From: Erin Moore
Sent: Monday, March 24, 2014 3:24 PM
To: Kaycee Hathaway; Holly Duncan; Joe Gilbert
Subject: RE: Kittitas County Notice to Agencies BL-14-00006 Trinity Farms

BL-14-00006 Trinity Farms

Forman / Shelton BLA

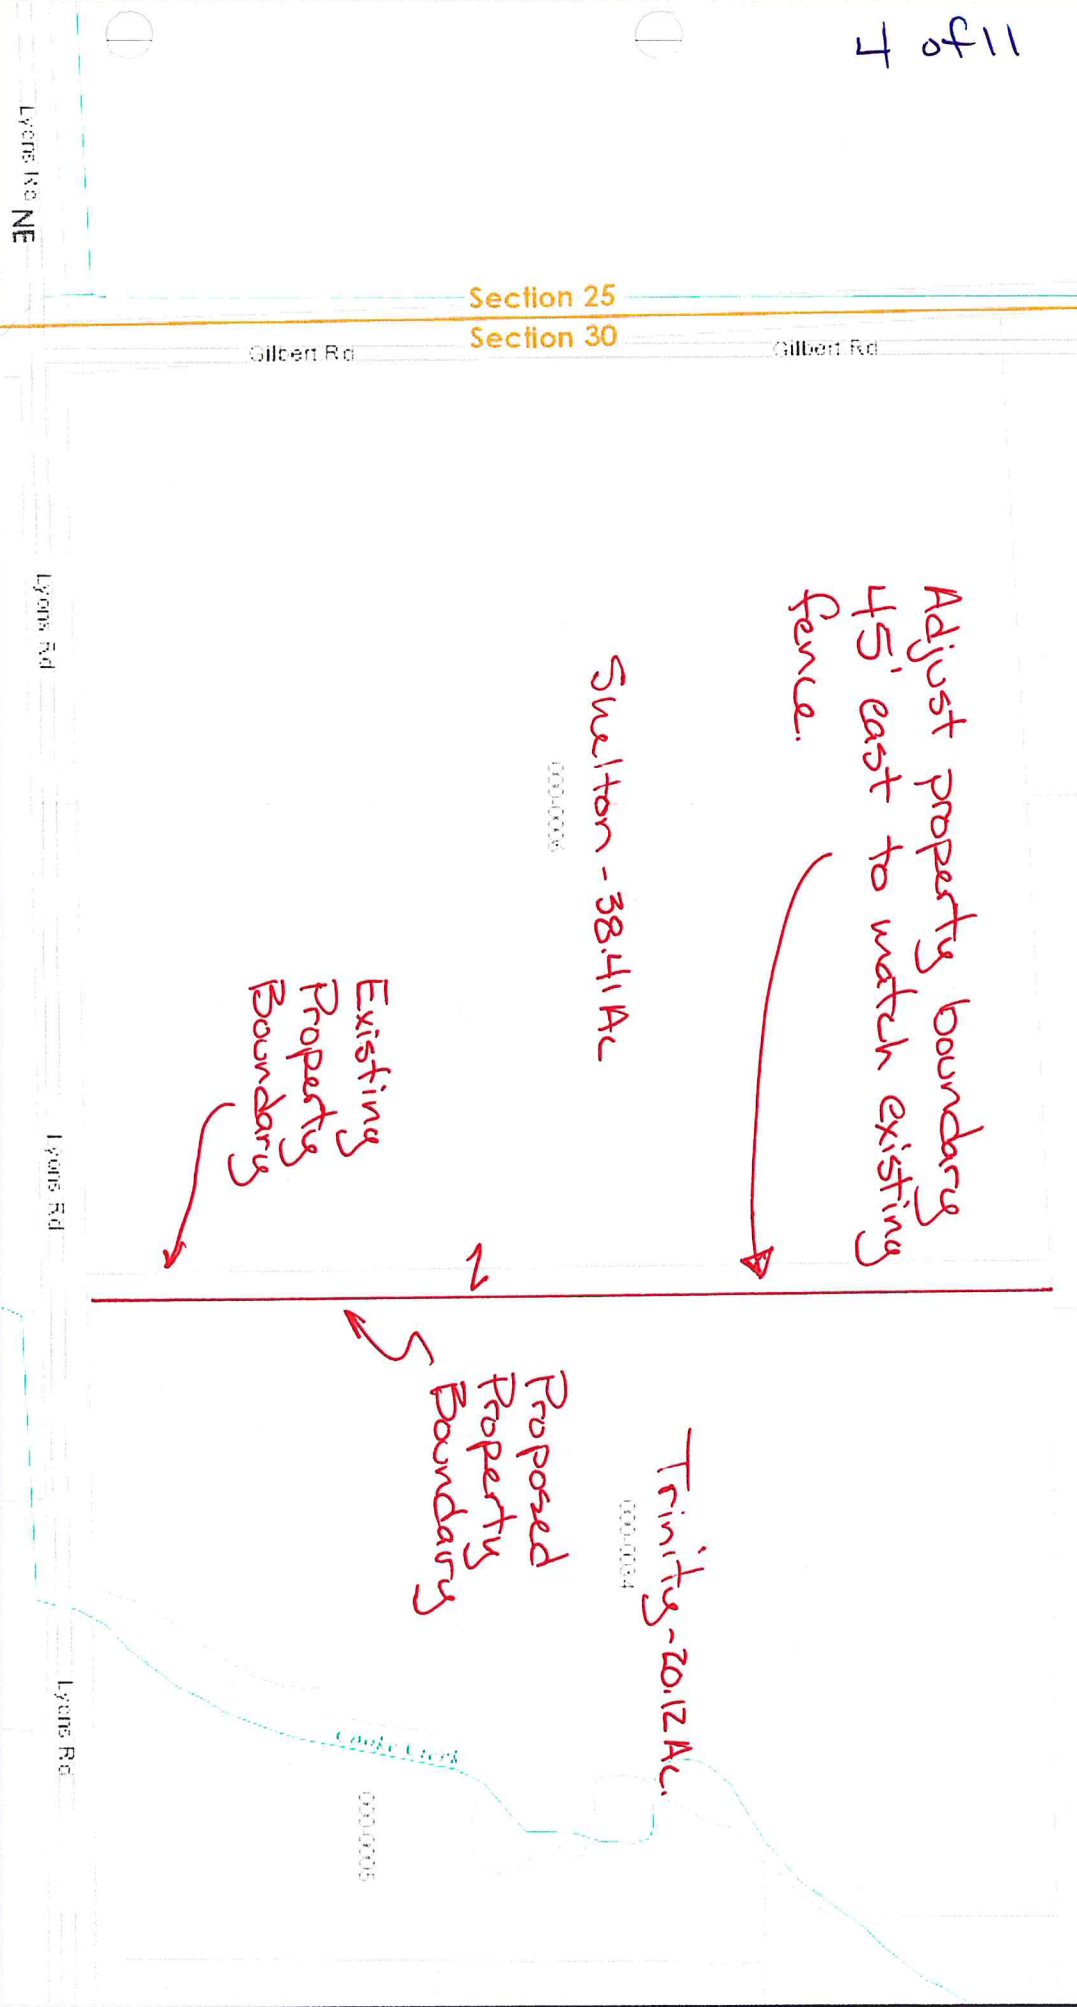
Please forgive me if I have missed it, but I do not see where the existing well and septic locations are. We need to know that in order to comment. Thank you!
